# ENG-SP18004-R4-PDRFDR-redlines.pdf Markup Summary

## DESIGN POINT D8 - Exist. 24in. Culvert

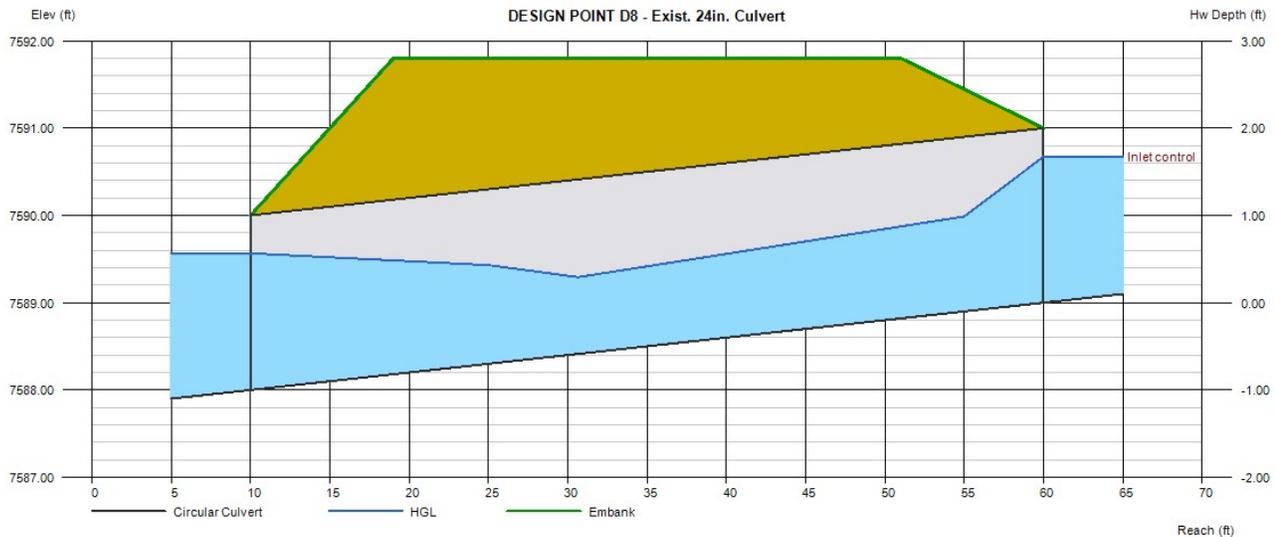
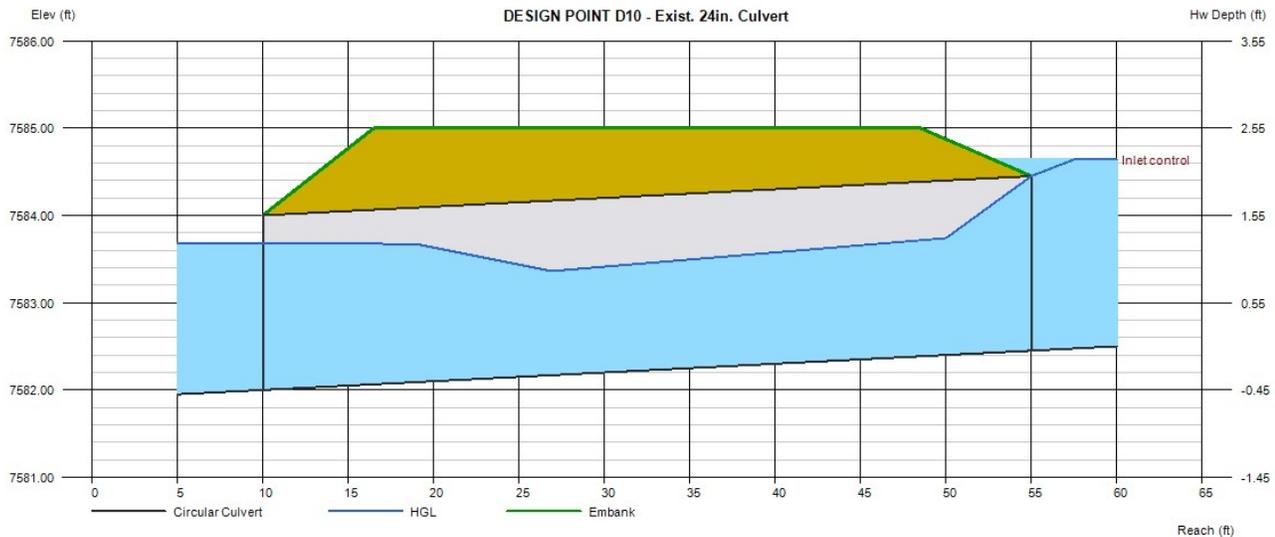
Does this culvert need to be modified?

**RETAIL RANCH**  
PRELIMINARY/FINAL DRAINAGE REPORT  
DEVELOPED DRAINAGE MAP

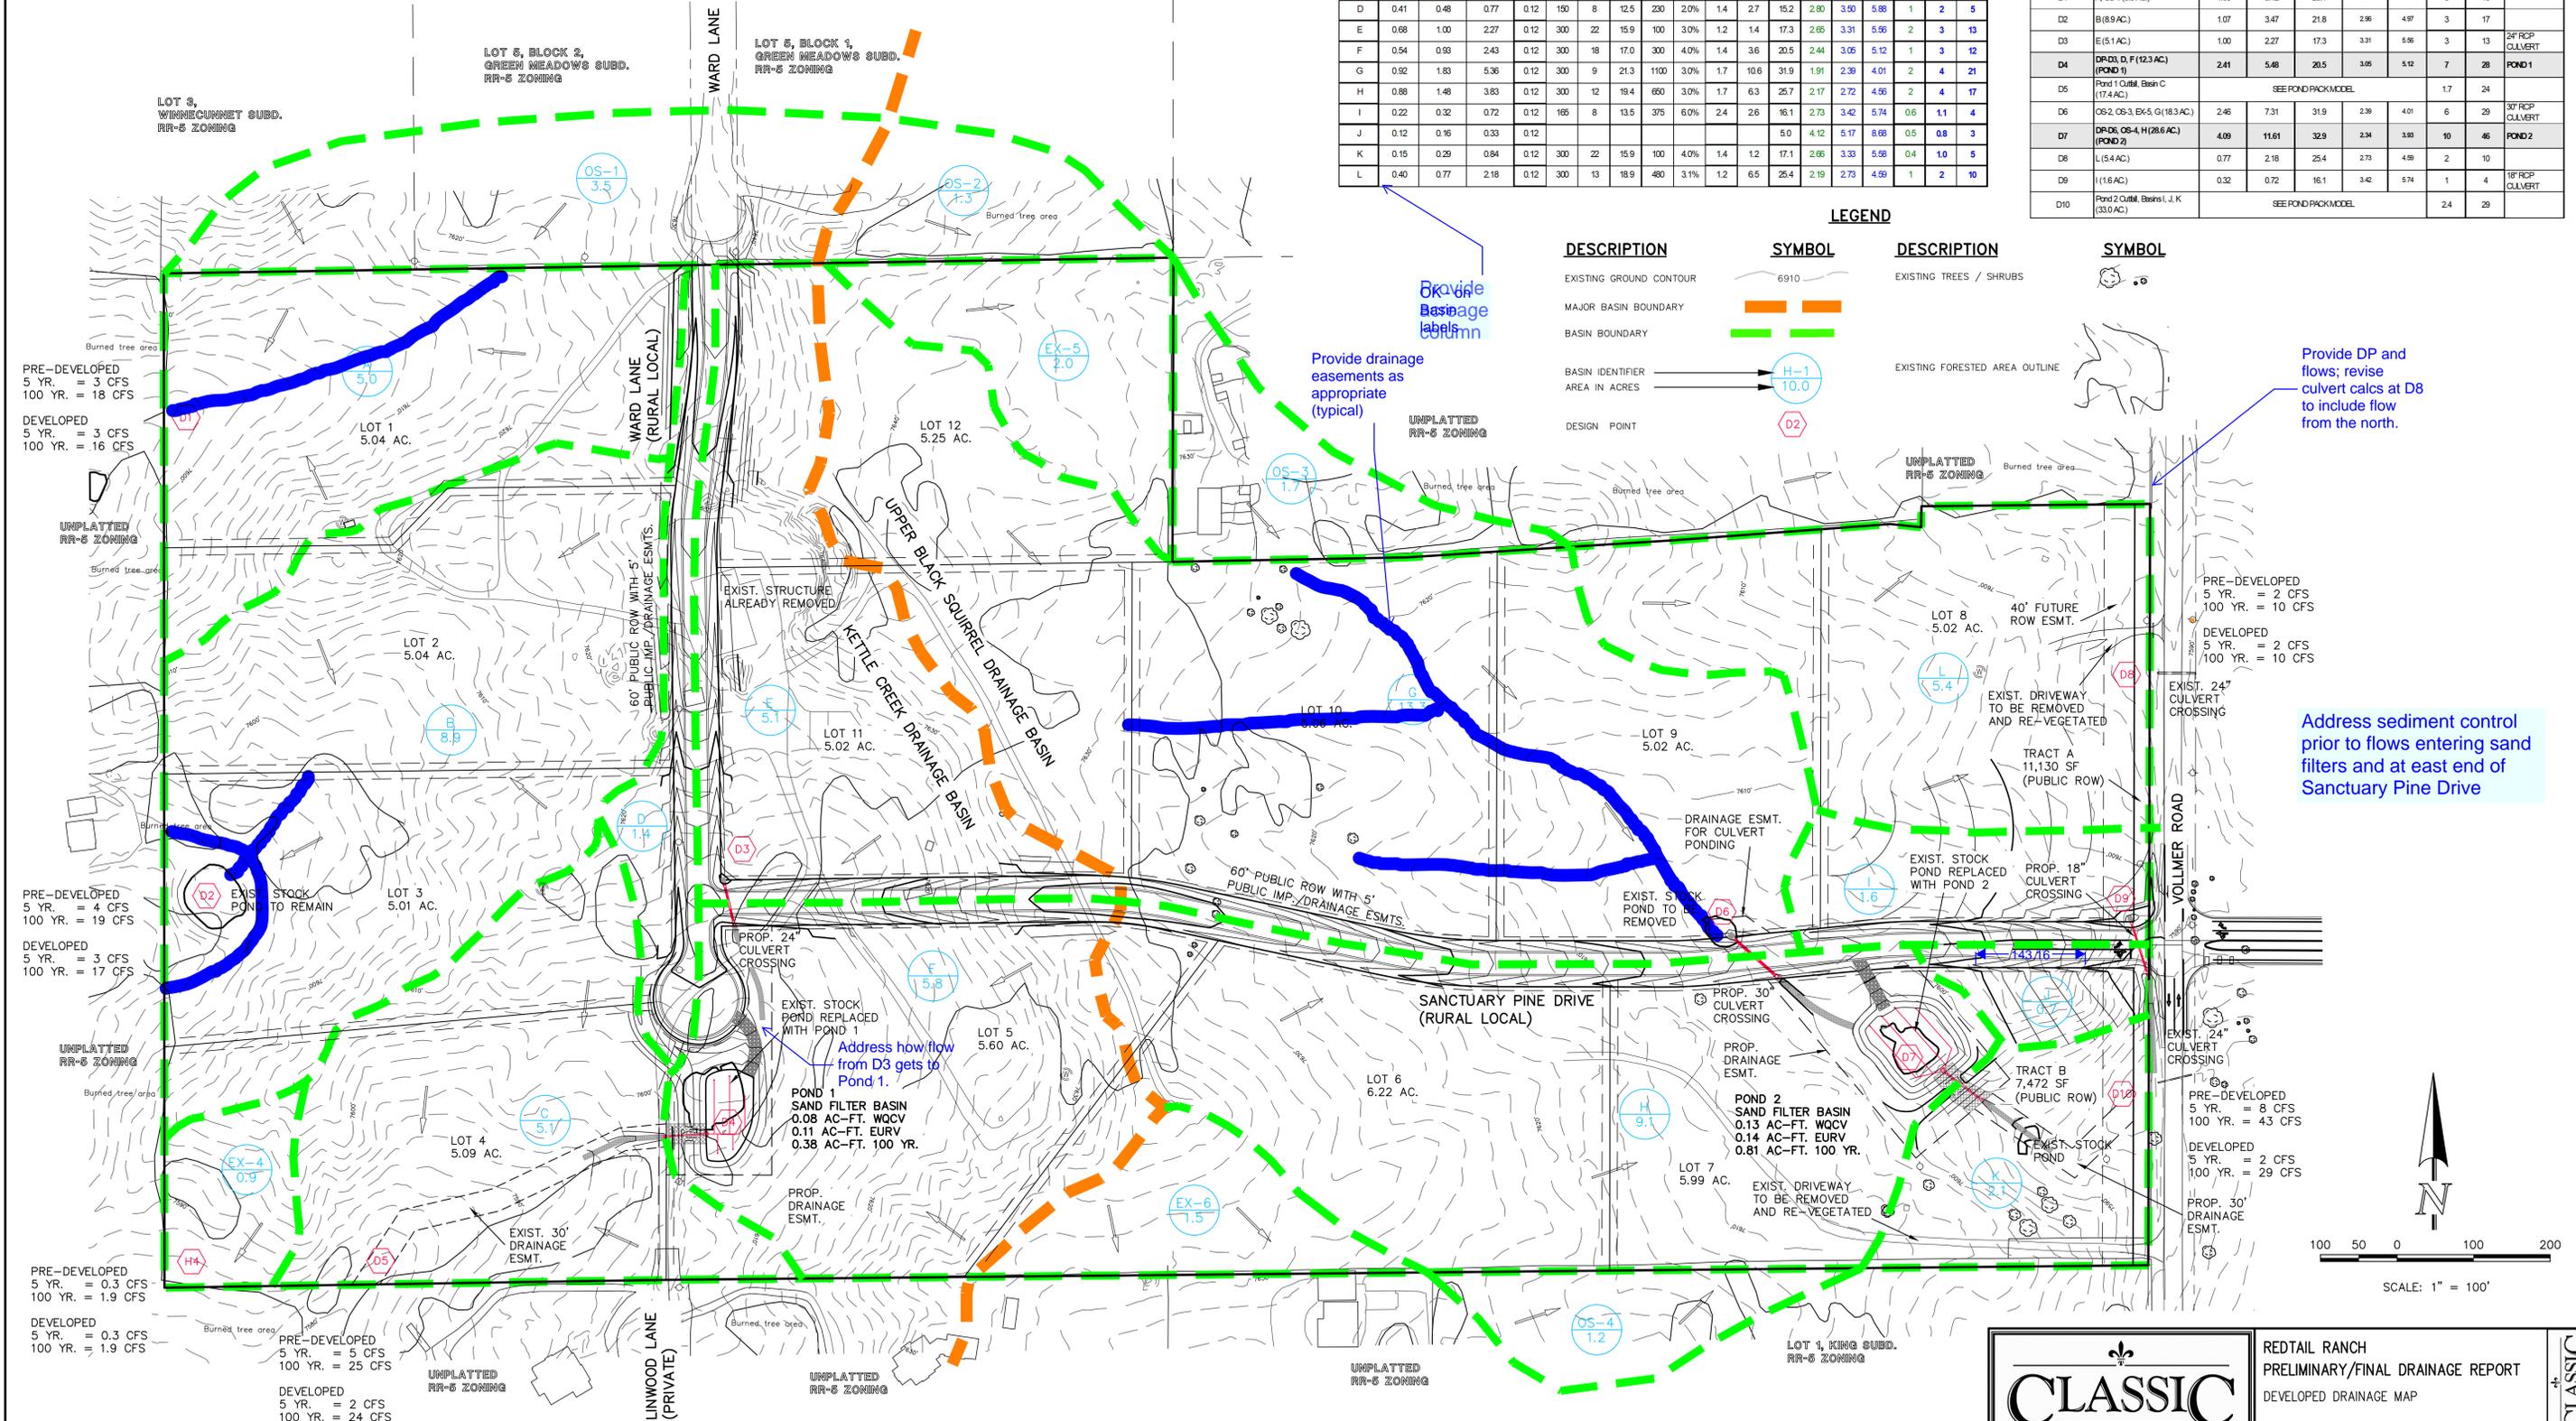
Address roadside ditch stabilization and  
calculations and plan in appendix.
